From: Nathanael Stock
Sent: 21 January 2022 19:09
To: DC Support
Subject: FW: Oxfordshire County Council response to 21/02893/REM, North Of Shortlands And South Of High Rock, Hook Norton Road, Sibford Ferris

From: Plater, Roger - Communities <Roger.Plater@Oxfordshire.gov.uk>
Sent: 07 December 2021 13:25
To: Nathanael Stock <Nathanael.Stock@Cherwell-DC.gov.uk>
Subject: RE: Oxfordshire County Council response to 21/02893/REM, North Of Shortlands And South Of High Rock, Hook Norton Road, Sibford Ferris

### Vehicle and Cycle Parking

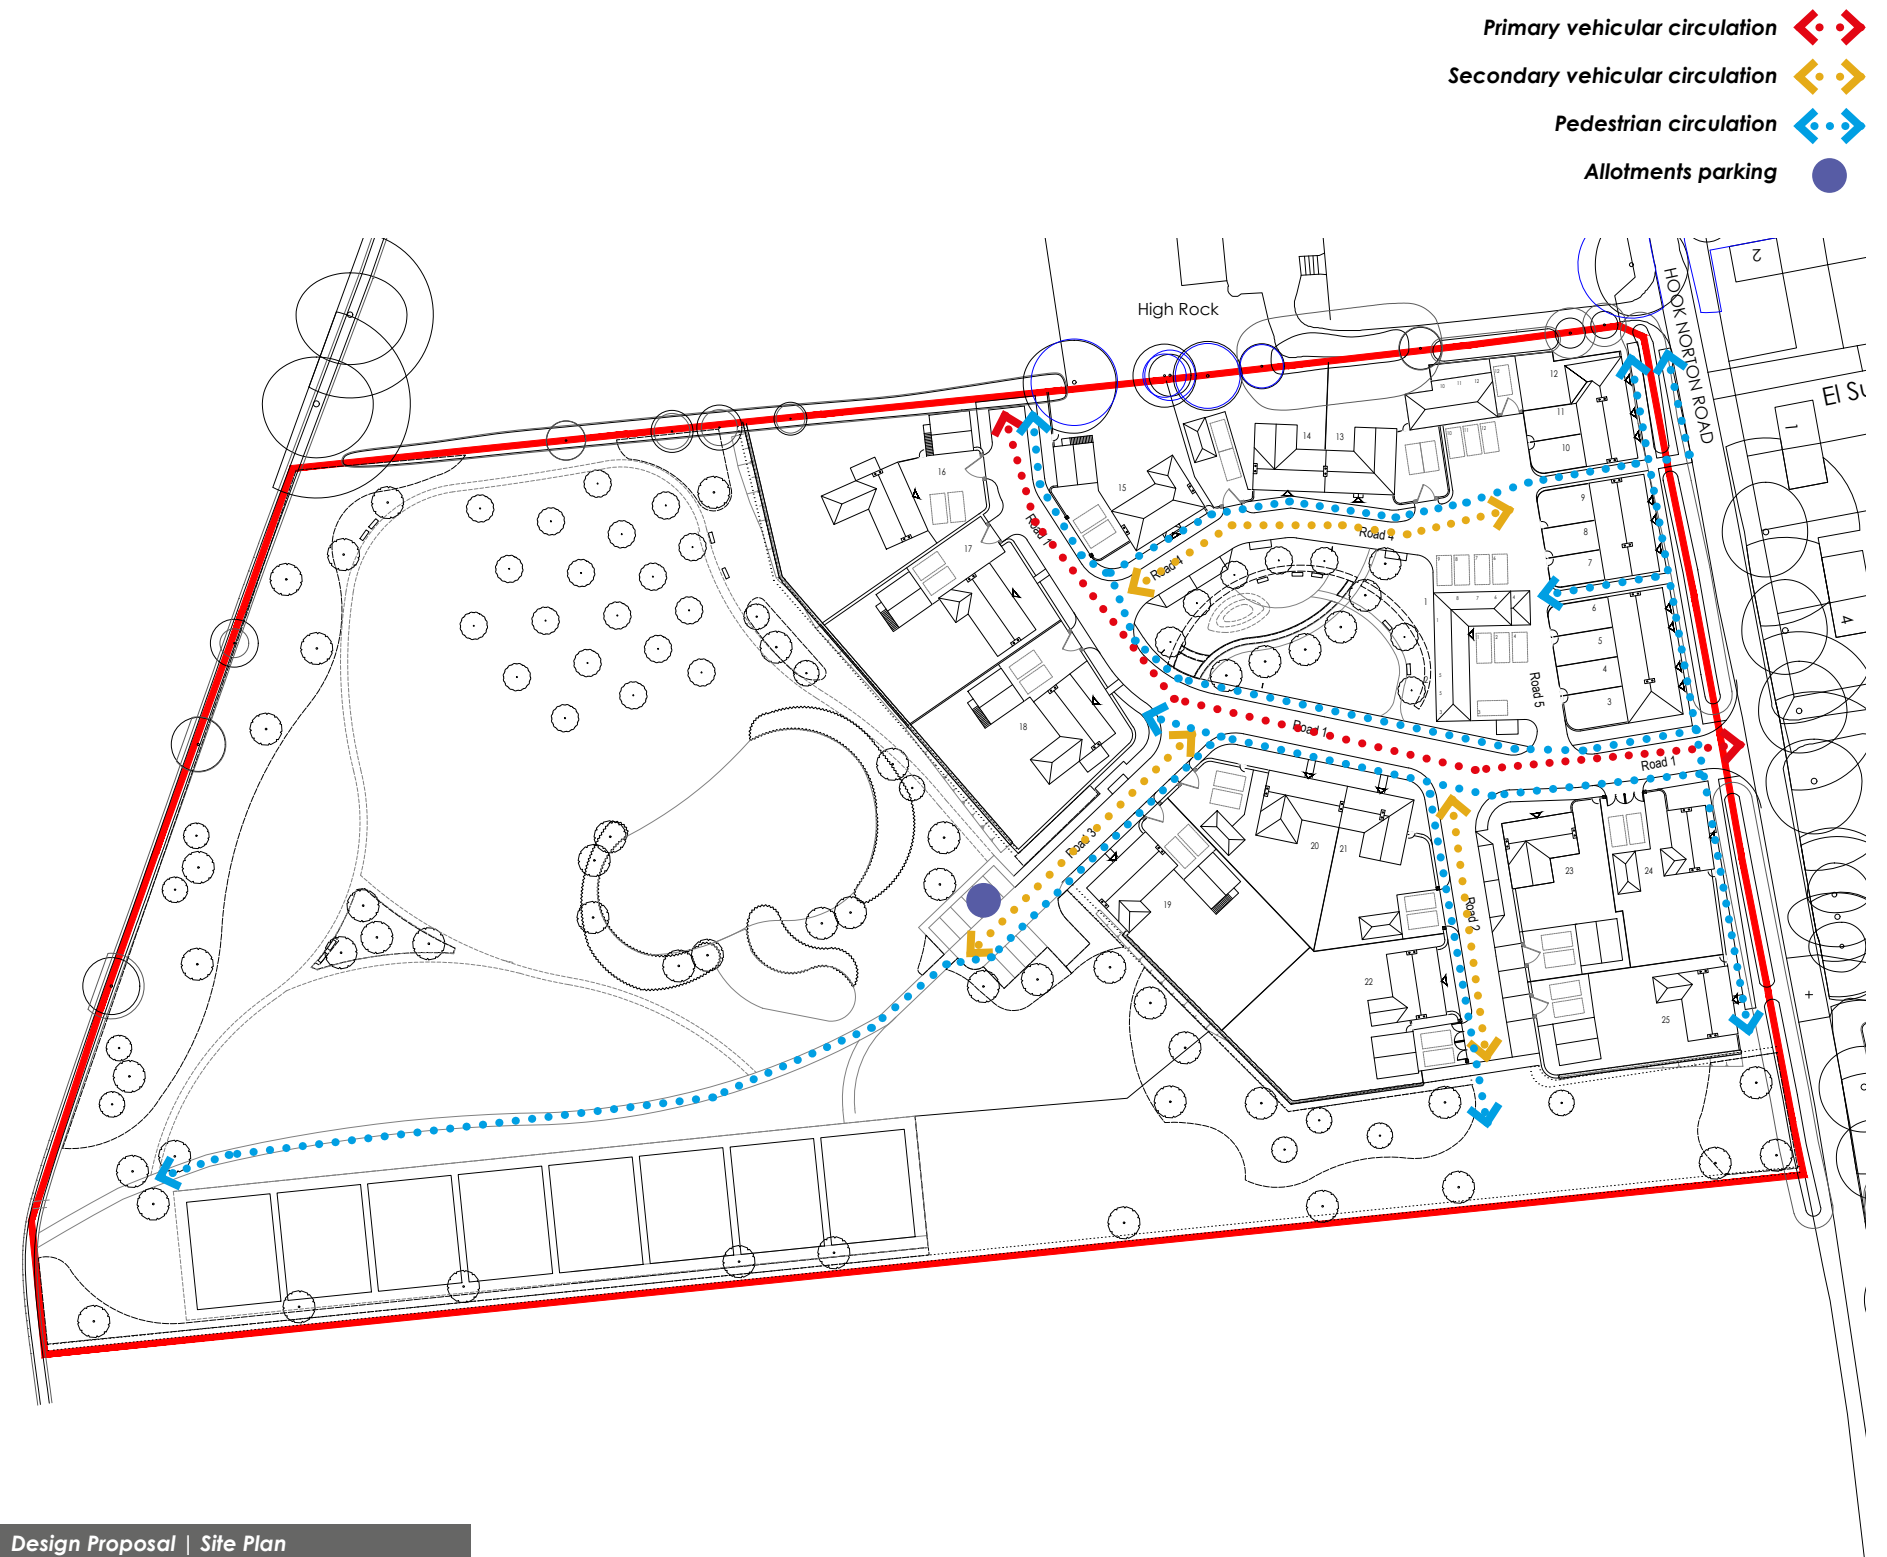
Paragraph 4.31 of the Planning Statement correctly says that “*Parking provision is to be provided in accordance with Table A6.B1 of the Oxfordshire County Council Residential Street Design Guide (2015)*” and reproduces that table. However, there is no follow-up calculation, so I have done it and reproduce it here:

Number of bedrooms				
	1	2	3	4	5
Plot nos.	1,2	4,5,6,7,8,10,11	3,9,12,24	13,14,15,17,19, 20,21,22,23,25	16,18
Occurences	2	7	4	10	2
Unallocated spaces per plot	0.4	0.3	0.3	0.5	0.5
Unallocated spaces required	0.8	2.1	1.2	5	1
Total number of unalocated spaces	10.1

As you see, there should be ten visitor spaces.

You say the ten spaces at the end of Road 3 are to serve the allotments. They are not particularly well-placed for that purpose, with a considerable walk to the furthest plots. What’s more, why do there need to be ten spaces for eight allotments? These spaces may get used for overspill from the residential development but are not well-placed for that either. I think the four unallocated spaces in the development are a significant under-provision seeing that it should be ten according to the standards and if the allotment parking is ignored.
